Application Reference: P/29/25/DOC Site Name: Land North of Hook Lane Pagham PO21 3PB	Initial Issue Date: 18/07/2025 Issue Date: 18/07/2025 Reviewer Reference: ADC/EXT2/D2134/73
--	--

Condition 9: **Further information required**

ADC Drainage Comments	Designer Response	ADC Drainage Comments	Designer Response	ADC Drainage Comments
Date:	12/07/2024				
Condition Number: 9 [Surface water Drainage Design]

Rev.	Description	Date	Initials	Checked
INFORMATION				
Client	SIMPLY UK			
Location	HOOK LANE PAGHAM, PO21 3PB			
Drawing Title	PROPOSED FORMATION LEVELS FOR CAR PARK			
Date	Drawn by	Scale	Checked	Date
NOV 25	AL	1:1	LC	NOV 25
Project Ref.	9418		Dwg. No.	C017
Rev.	1

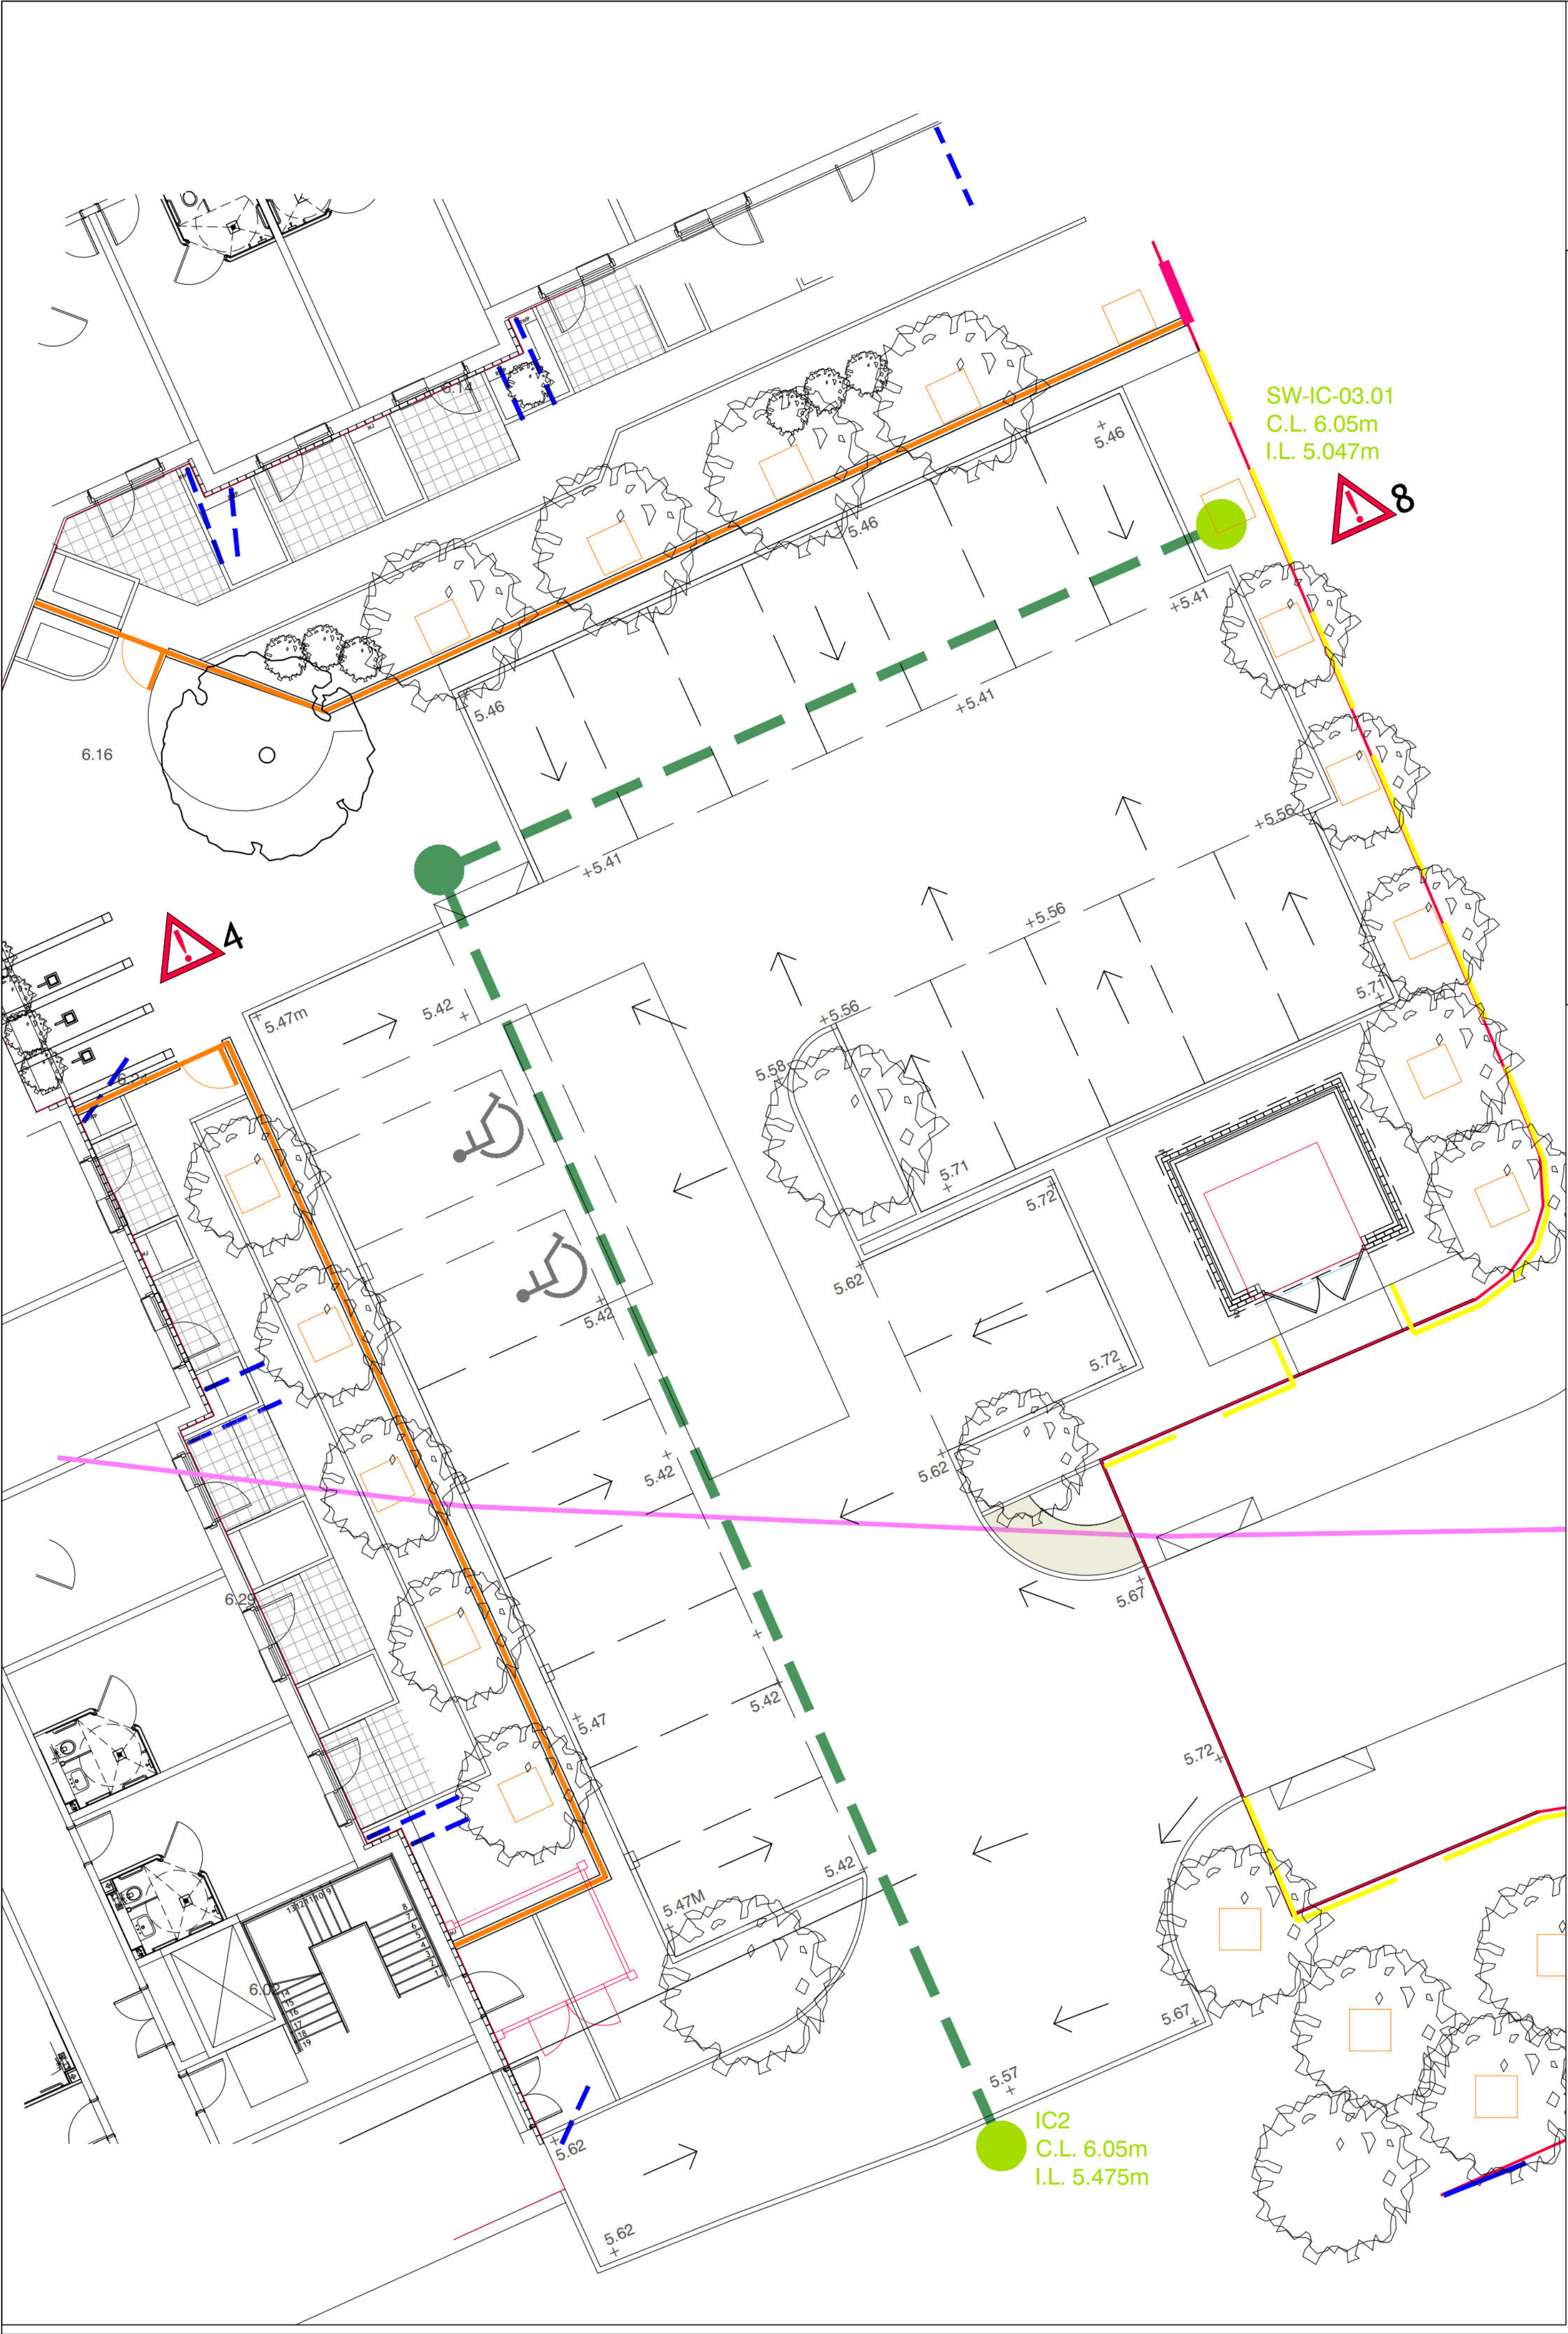
11.	Provide a detailed level design to clearly demonstrate that surface water run off will discharge to the proposed gullies/permeable paving etc. and not cause a risk of flooding to the building or off site. A) There are some large areas of paving around the buildings where levels have not been shown or are sparse. Please demonstrate that there are adequate falls for these areas to be drained as intended. The manhole cover levels on the drainage drawing suggest some of these areas are flat B) Levels of the formation of the permeable paving must be provided	A. See Rev. C Calculations - Updated Drawings & Calculations. B. The minimum thickness of subbase is 300mm thick and is graded out to low points. Contractor will install pipes accordingly to suit services.

TYPICAL INSPECTION CHAMBER DETAIL

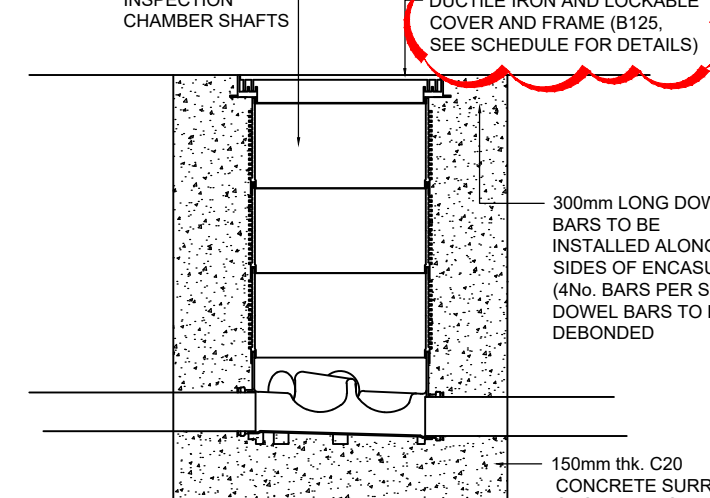
900mm is required from top of benching to underside of cover slab) o) The typical manhole detail shows a grade D400 cover which contradicts the manhole schedule p) The Typical inspection chamber detail appears to show a light duty cover which contradicts the manhole schedule Provide revised drawings and calculations that are coordinated and consistent	O. D400 covers are only shown on Manholes in Road/Parking areas. See Drainage Plan for details. Updated Drawings & Calculations. P. Inspection chamber covers are not shown on the Manhole Schedules. Updated Drawings & Calculations.

GRAF ECOBLOC MAXX STORAGE SYSTEM (ST1)
(21.6x2.4x0.61m - 30.04m³)

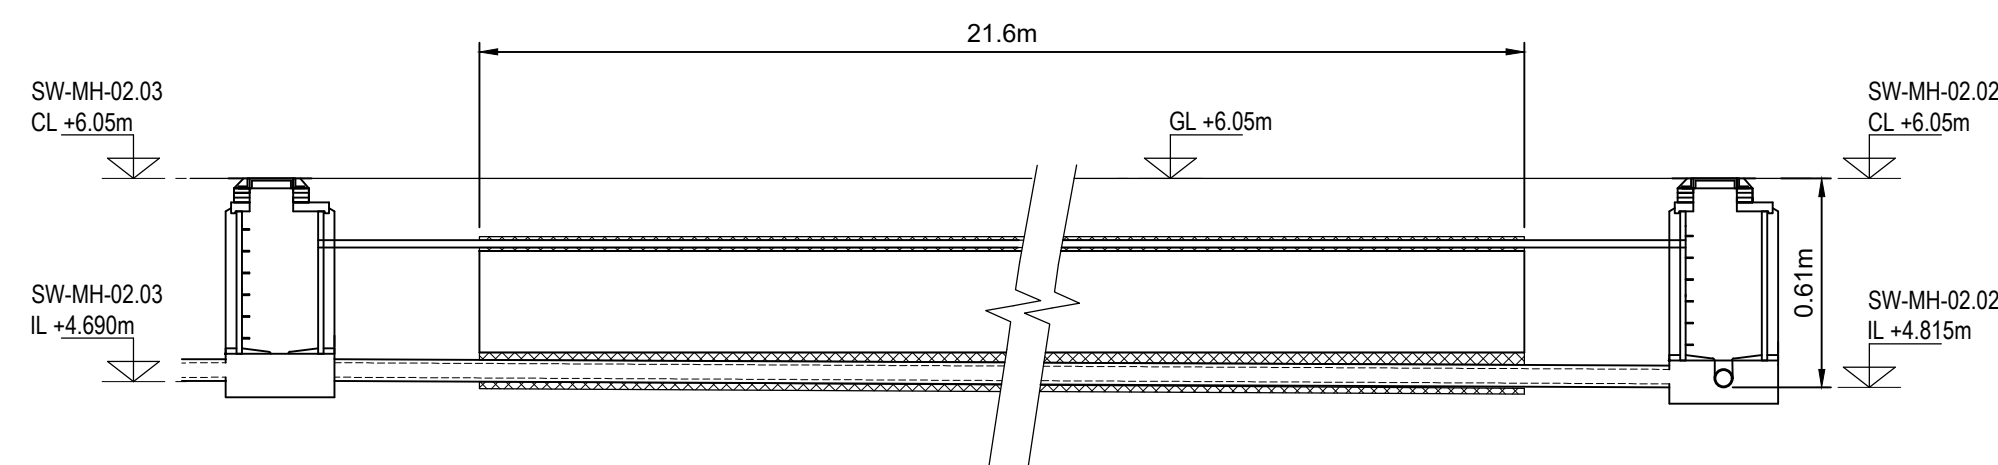
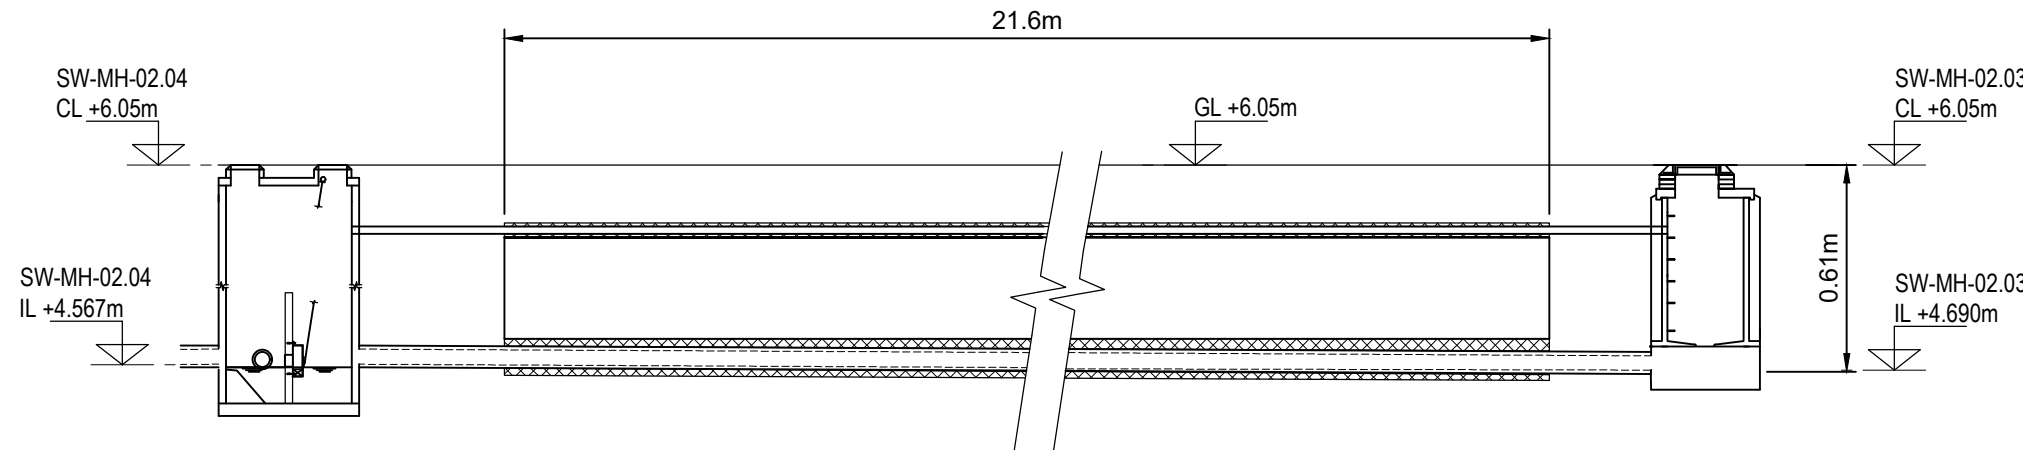
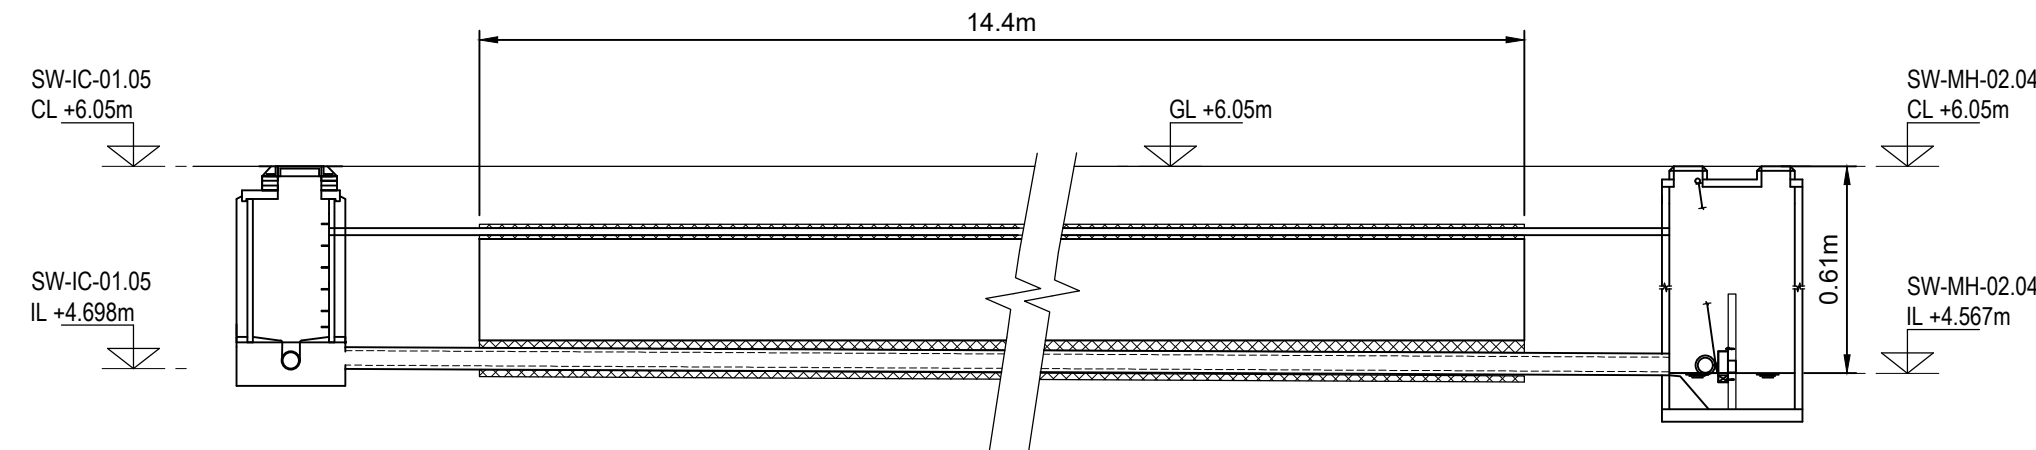
2.	Groundwater monitoring data has been submitted which shows groundwater level varies at depths of approximately 1 – 1.4m below ground level. This rules out the use of infiltration. Provide details of counter-buoyancy measures and calculations and for the proposed cellular storage tanks	2. CSP have provided flotation calculations in Appendix A.

e) Tank SW1 appears to be oversized in the calculations. The drawing states 21.6x3.6=77.76m². The calculations use an area of 82.1m² f) Calculations use a design head of 1.5m for the flow control, 1m is stated on the drainage plan g) The final connection is shown as 150mm dia on the drainage plan but 300mm dia in the calculations. It is shown with a gradient of 1:200. Demonstrate that this will be self cleansing with the proposed 2l/s flow rate. h) The calculations do not confirm pipe gradients or lengths i) The calculations do not include invert levels but a check using the chamber depth shows that that invert levels in the calculations are not consistent with the drawings. j) The calculations do not include results for all required design storm events k) The calculations do not include the FEH22 point descriptor information. Ensure calculations are consistent with the drawings and show all information	E. This will have no impact on calculations or drawings. Updated Drawings & Calculations. F. This was answered in Rev. C calculations. Updated Drawings & Calculations. G. Responded in previous Rev. C calculations. Updated Drawings & Calculations. H. These details are ALL in the Rev. C calculations. Pg25-28 including other sections. Updated Drawings & Calculations. I. These details are ALL in the Rev. C calculations. Pg25-28 including other sections. Updated Drawings & Calculations. J. Replied in Rev. C calculations. Updated Drawings & Calculations. K. These details were included in Rev. C calculations. Updated Drawings & Calculations.
